Submissions Report

*SSD-87486461
20-22 Atchison Street, St
Leonards*

This Response to Submissions Report (**Submissions Report**) has been prepared on behalf of Setia Sydney Pty Ltd (the **Applicant**) in relation to State Significant Development Application (**SSDA**) 87486461 for the residential development at 20-22 Atchinson Street St Leonards (the **site**). This report has been prepared to address the matters raised by public agencies, local Council, the community and other relevant stakeholders throughout the public exhibition period.

Existing Through-Site Link Plan
NTS

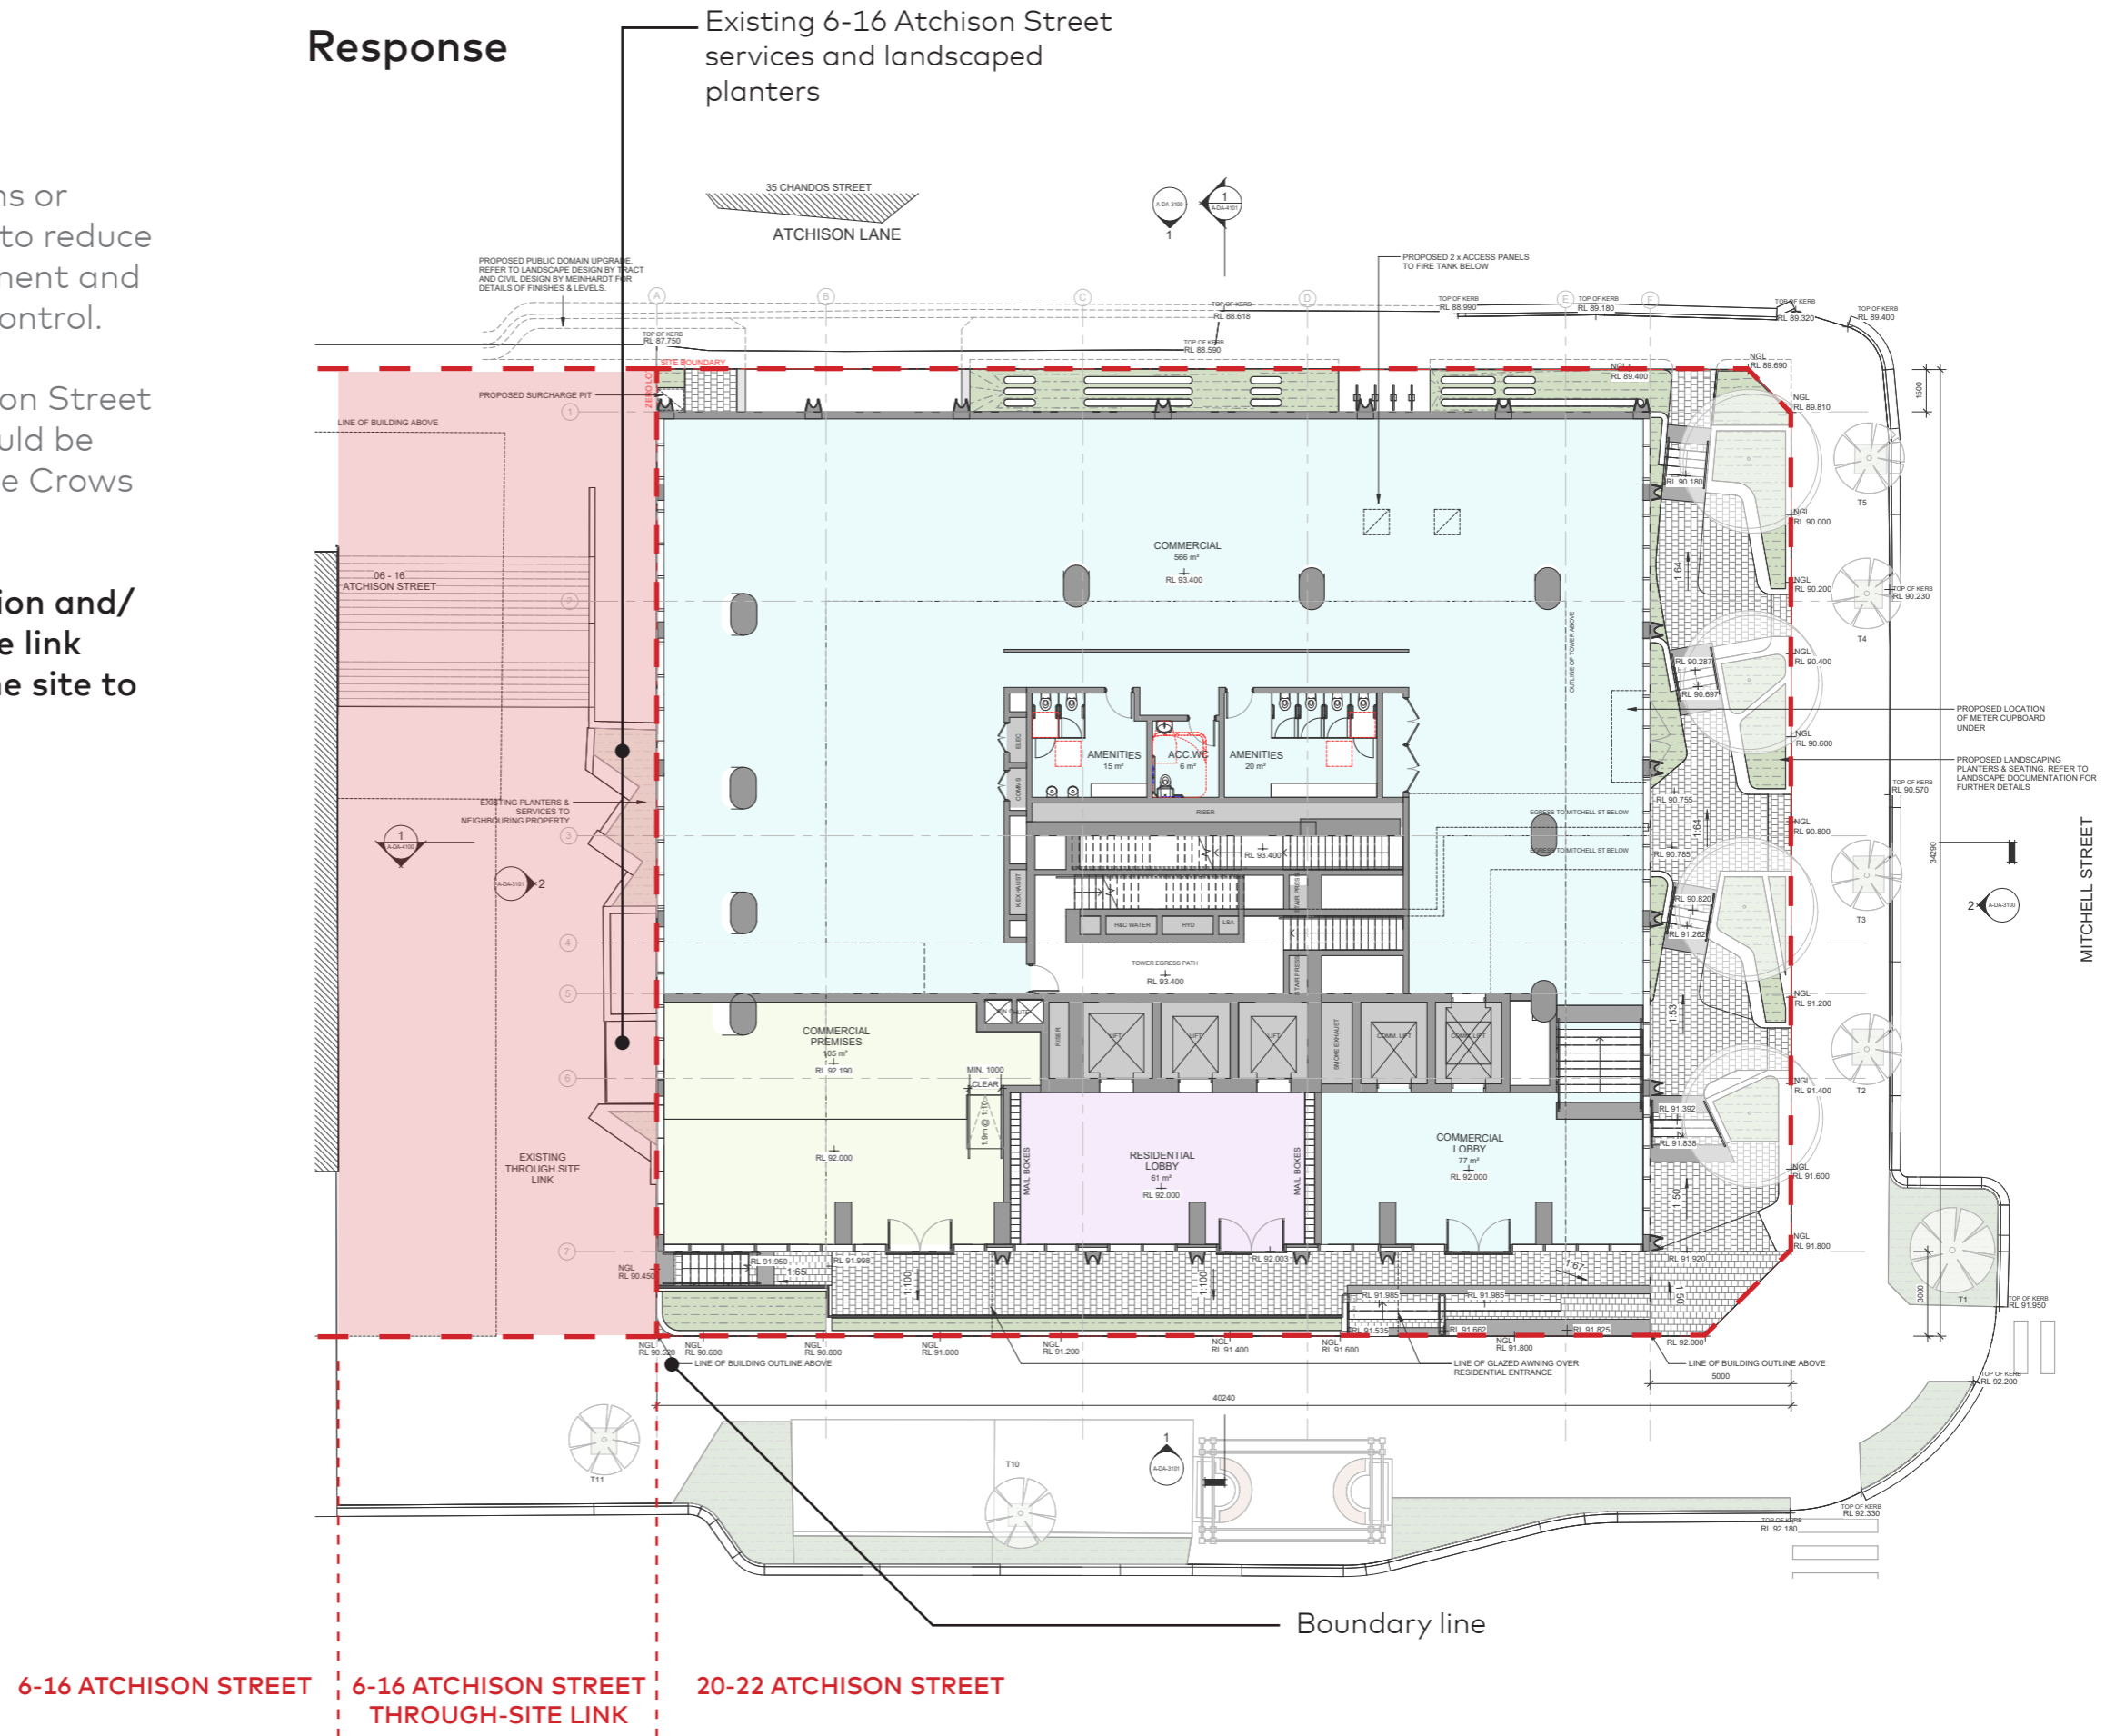
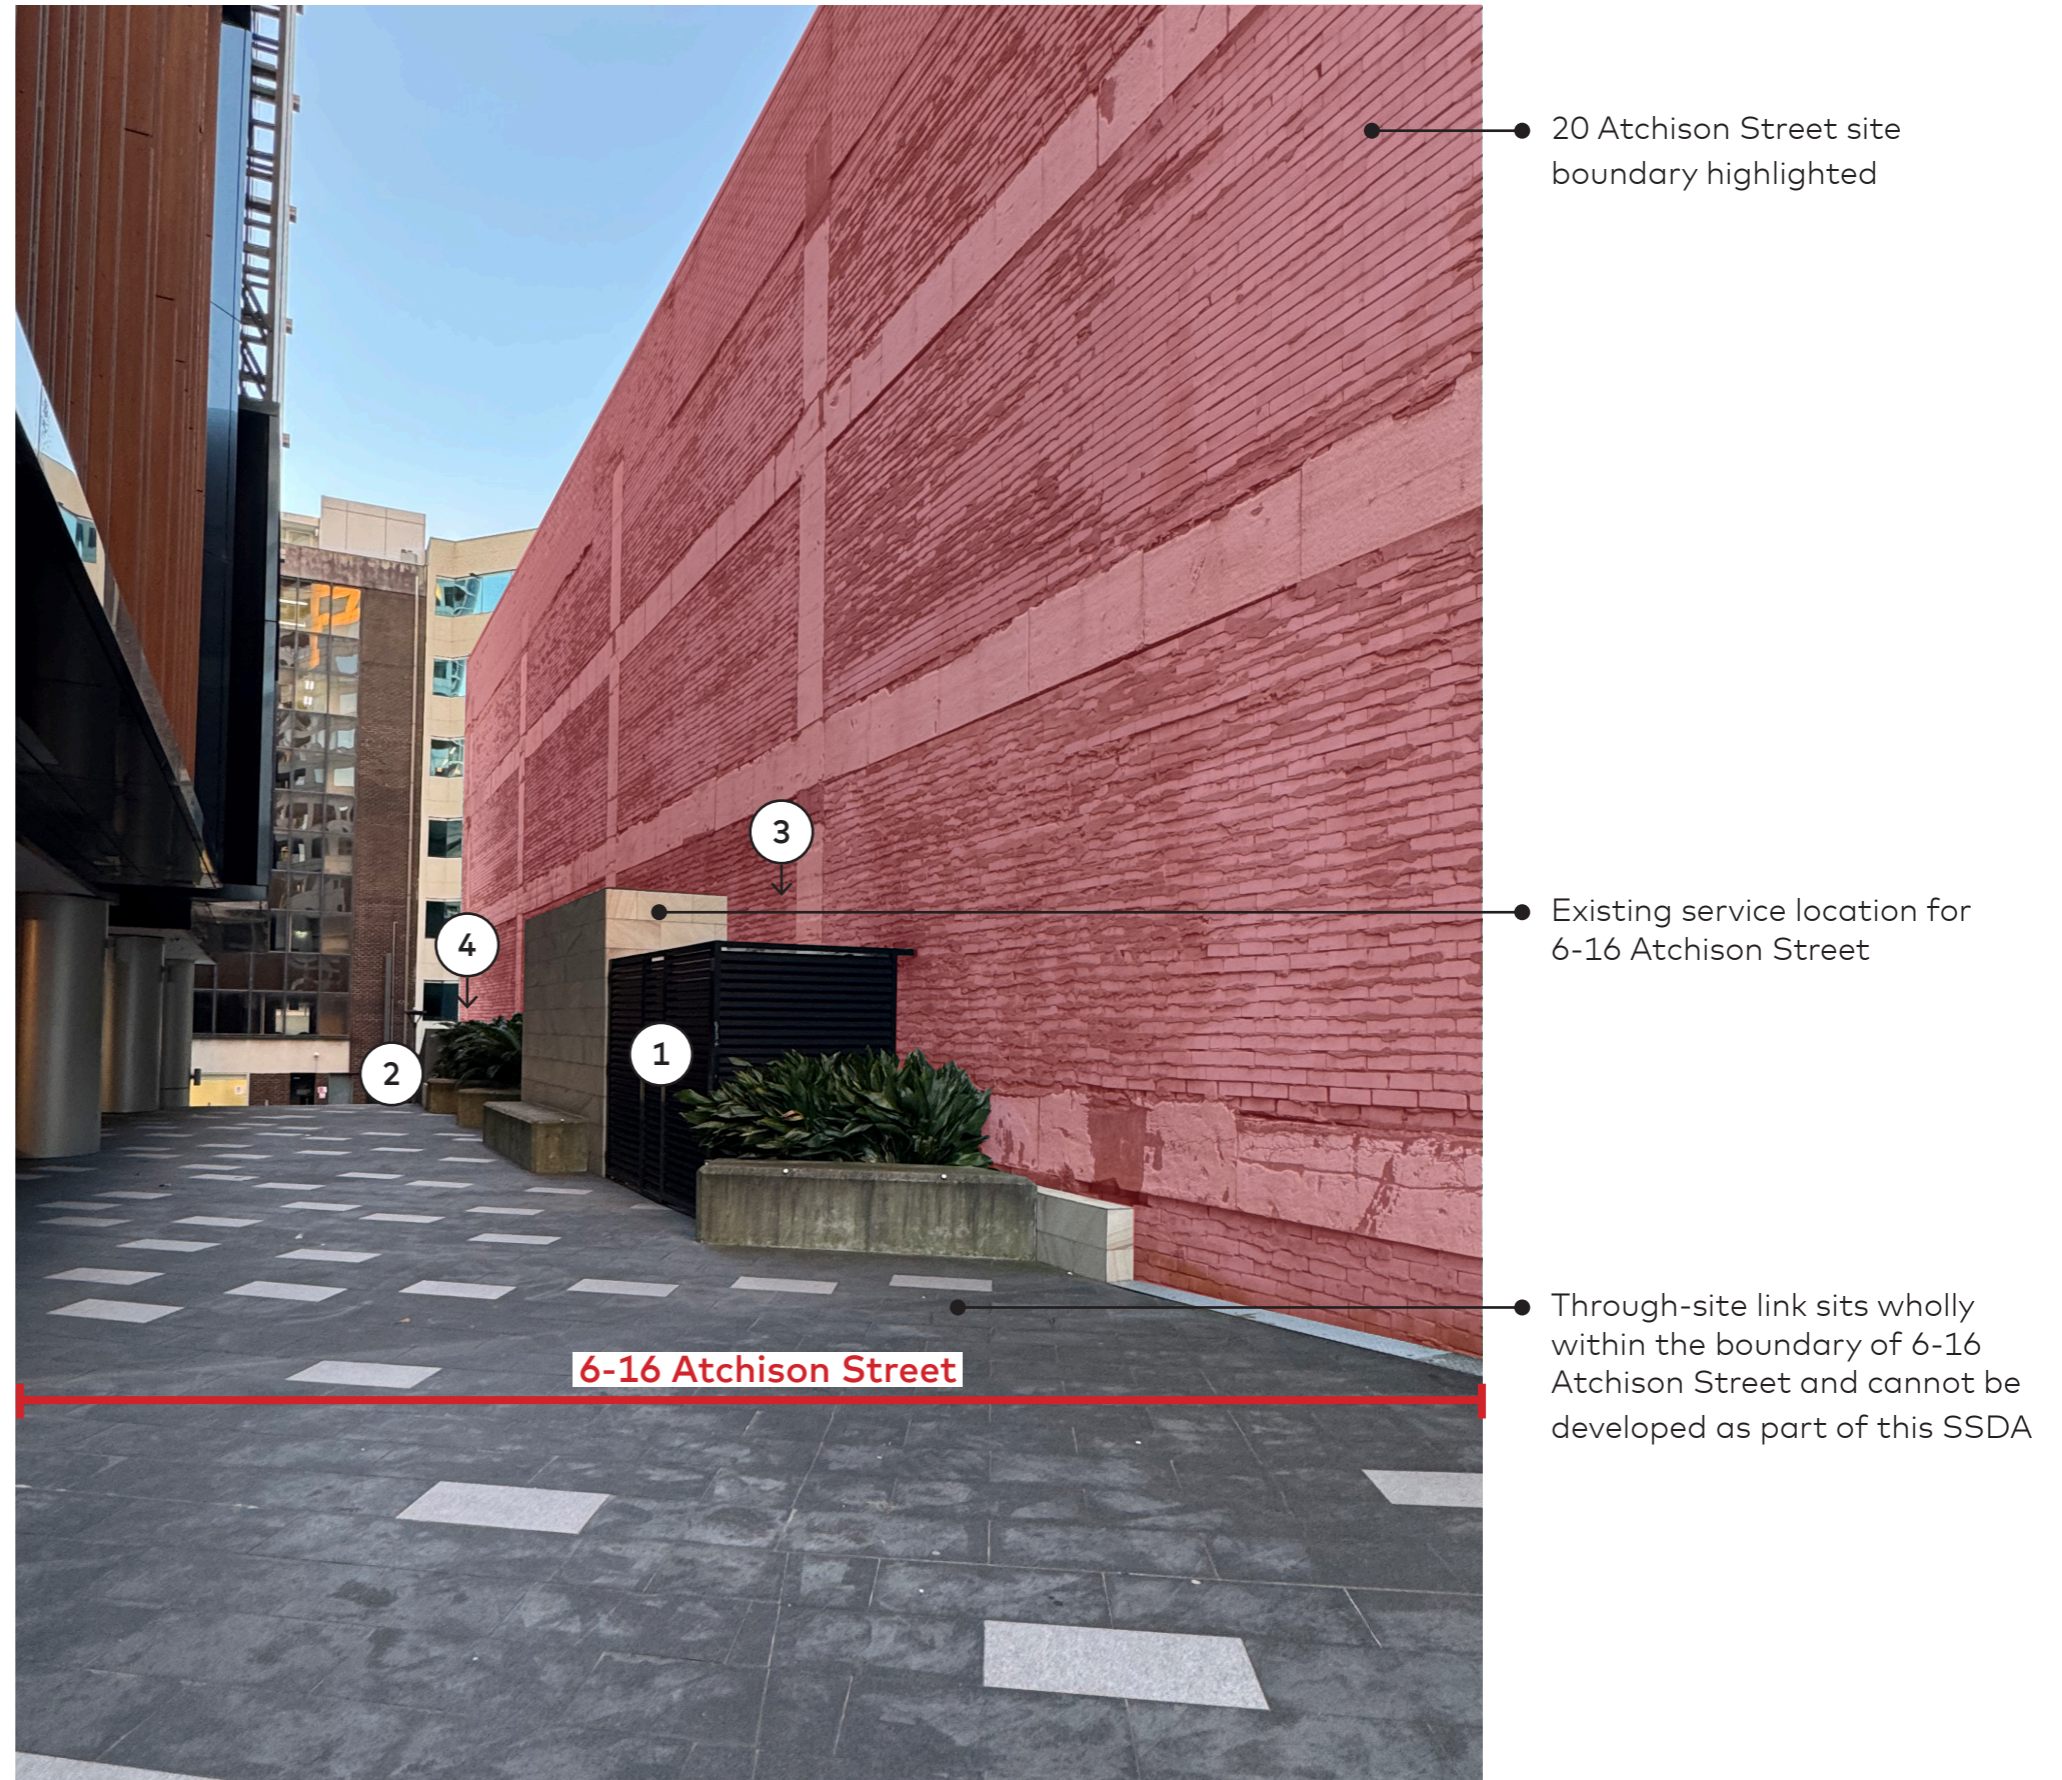
<p><i>c) Consider improved street activation and/or landscaping of the through -site link along the western boundary of the site to screen the inactive facade.</i></p>	<p>A proposed public art zone has been proposed along the western boundary of the site. This public art zone is to be implemented by the applicant post-approval during the detailed design development stages. This provides an opportunity to activate the blank edge of the podium facing the existing through-site link. This is considered a more feasible and long-term design solution to landscaped walls, as feasible testing on a successful Greenwall (by a Landscape Architect) identified that the western façade is subject to a significantly unfavourable microclimate due to:</p> <ul style="list-style-type: none"> ▪ Severe lack of natural light due to overshadowing from adjacent built form ▪ Persistent wind exposure and downdraft effects, typical within narrow through-site links and high-rise urban environments ▪ Temperature fluctuations that create plant stress and reduced survivability 	Appendix I Appendix L

Level 2 Cross Ventilation Plan
NTS

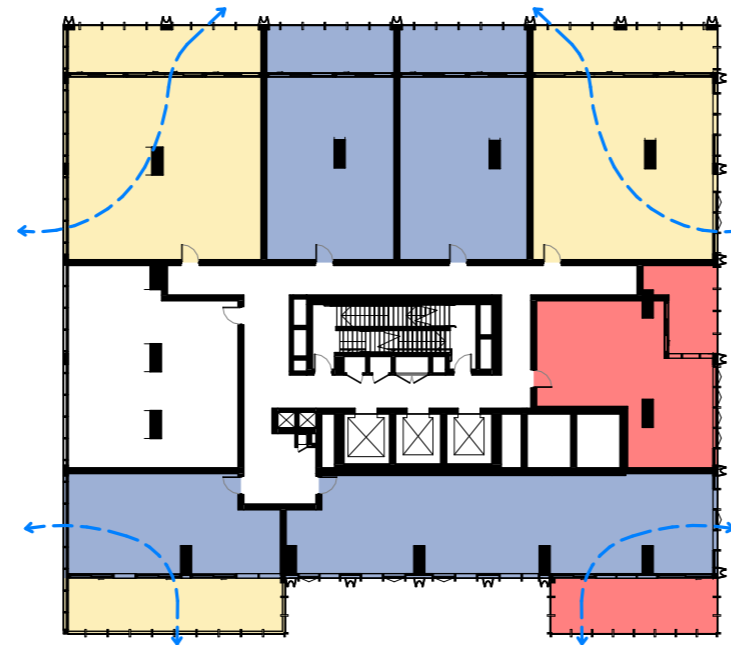
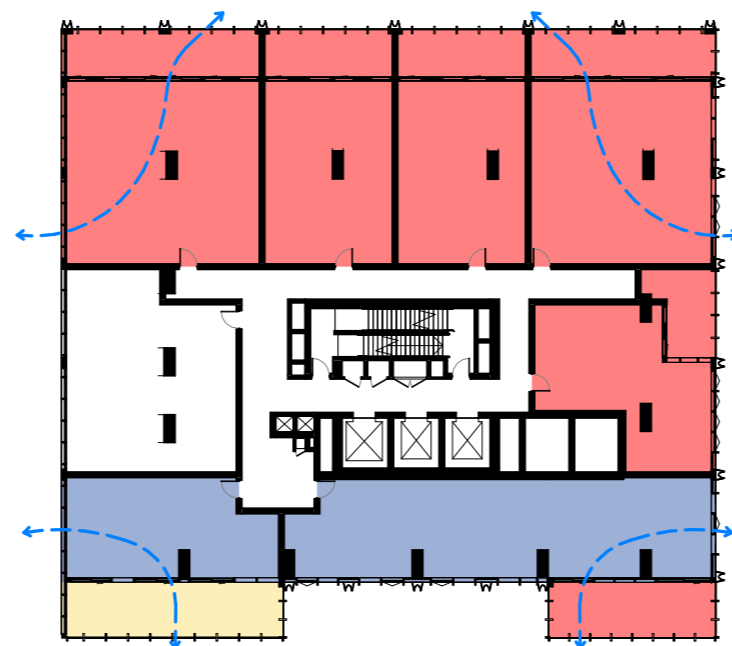
Key Issue	Description	Response	Refer to
		<p>level to diversify the market and activate the street frontages.</p> <p>The total non-residential FSR is 1.41 FSR.</p>	
	<p><i>b) Consider increased setbacks for the residential podium Levels 2 and 3 to more closely align with the building separation distances recommended in the Apartment Design Guide (ADG).</i></p>	<p>Alternative design options have been considered to increase setbacks at Levels 2 and 3; however, it is concluded that these options do not result in an improved planning or urban design outcome when compared with the current proposal. Increased setbacks would likely lead to a two-level street wall height, which would be inconsistent with the TOD Design Guide and the established and emerging character of the surrounding area.</p>	<p>Appendix L</p>
	<p><i>c) Confirm that the apartments identified as achieving natural cross ventilation can achieve this, as recommended in the ADG. Particularly the apartments on Levels 2 and 3 given the western elevation of building is a solid wall</i></p>	<p>As per SSDA submission, the cross-ventilation approach is to have operable awning panels at high level to facilitate cross ventilation while not providing views to neighbouring building. Refer to Figure 9 for details.</p> <p><i>Figure 9 Operable Awning Panels</i></p>  <p><i>Source: Cox Architects</i></p>	<p>Appendix L</p>
